This is an application for a single storey extension to an existing clubhouse at Thongsbridge Cricket Club Miry Lane Thongsbridge. The application site has vehicle access directly off Miry and the existing clubhouse and its facilities are long established.

title site layout & overflow parking
number 15093D-04-P01
scale 1:500
size A2

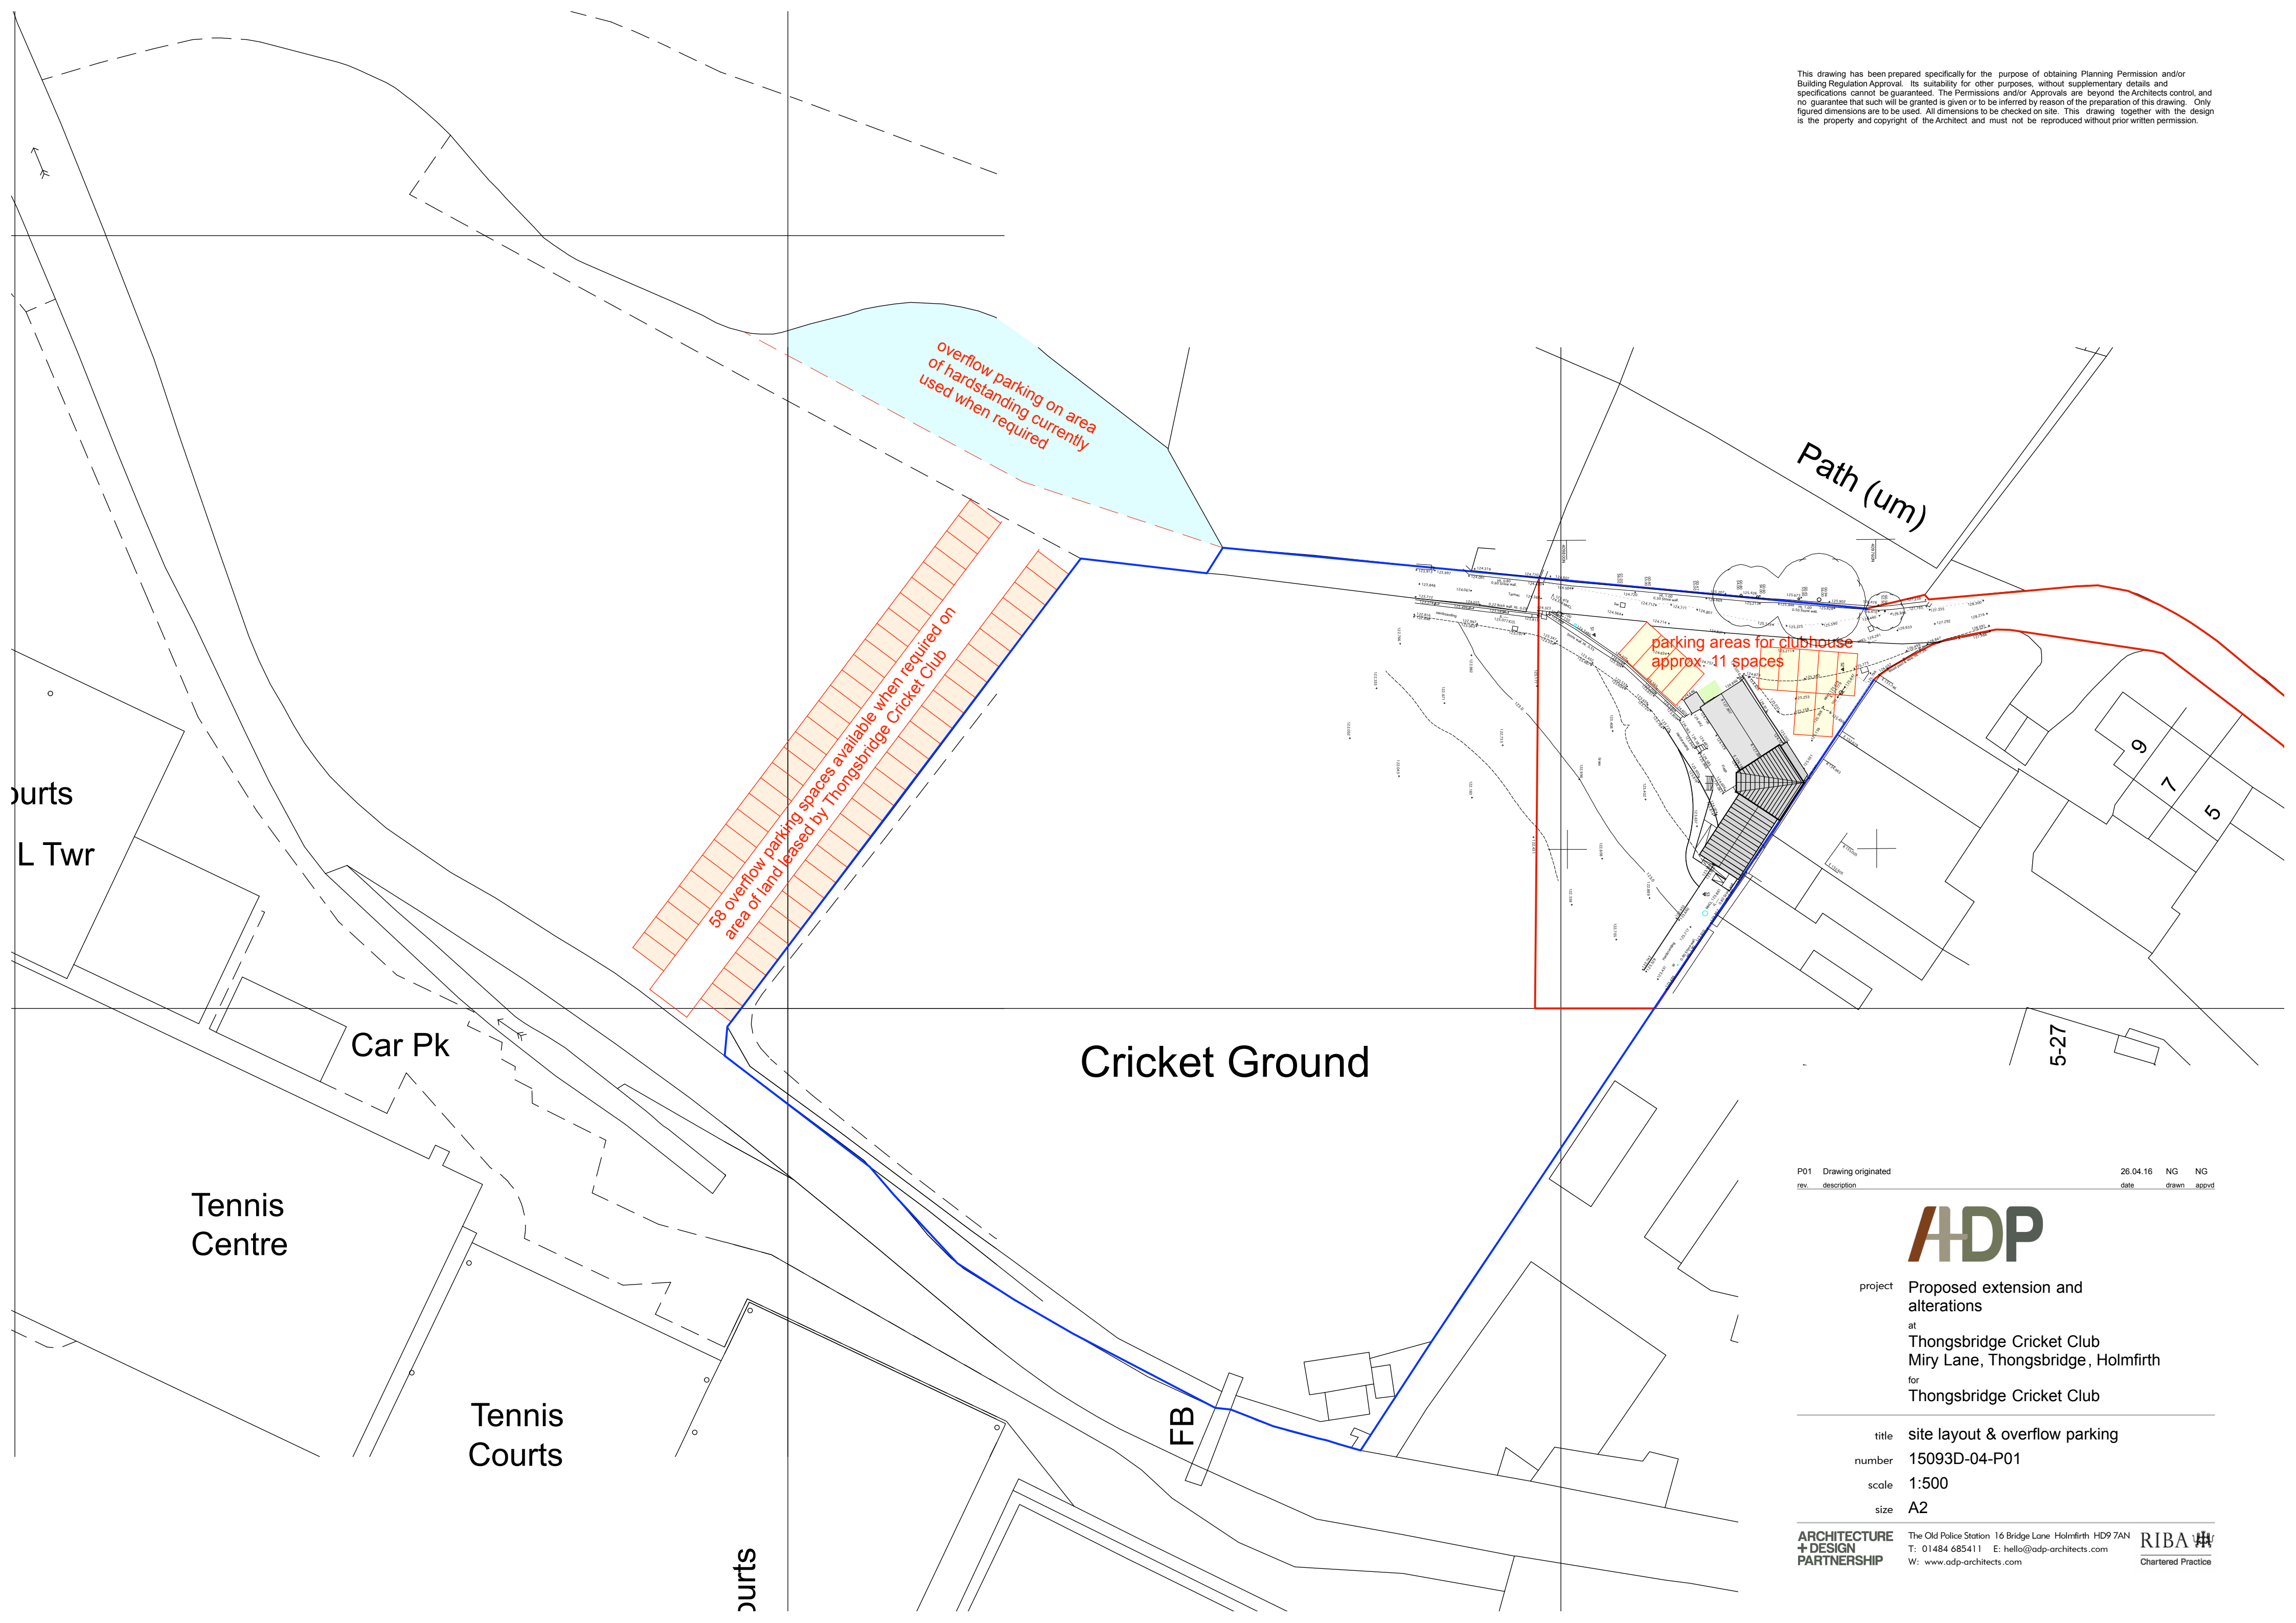
There is an indication that parking facilities will be extended and we would ask that for a condition to ensure that parking areas have appropriate surface and drainage provision.

The use of the development hereby permitted shall not commence until the car park has been provided, surfaced, sealed, marked out and drained in accordance with the Communities and Local Government; and Environment Agencies 'Guidance on the permeable surfacing of front gardens (parking areas)' published 13th May 2009 (ISBN 9781409804864) as amended or superseded in accordance with the permitted plans and the car park shall thereafter be retained for that purpose for the occupiers of and visitors to the development.
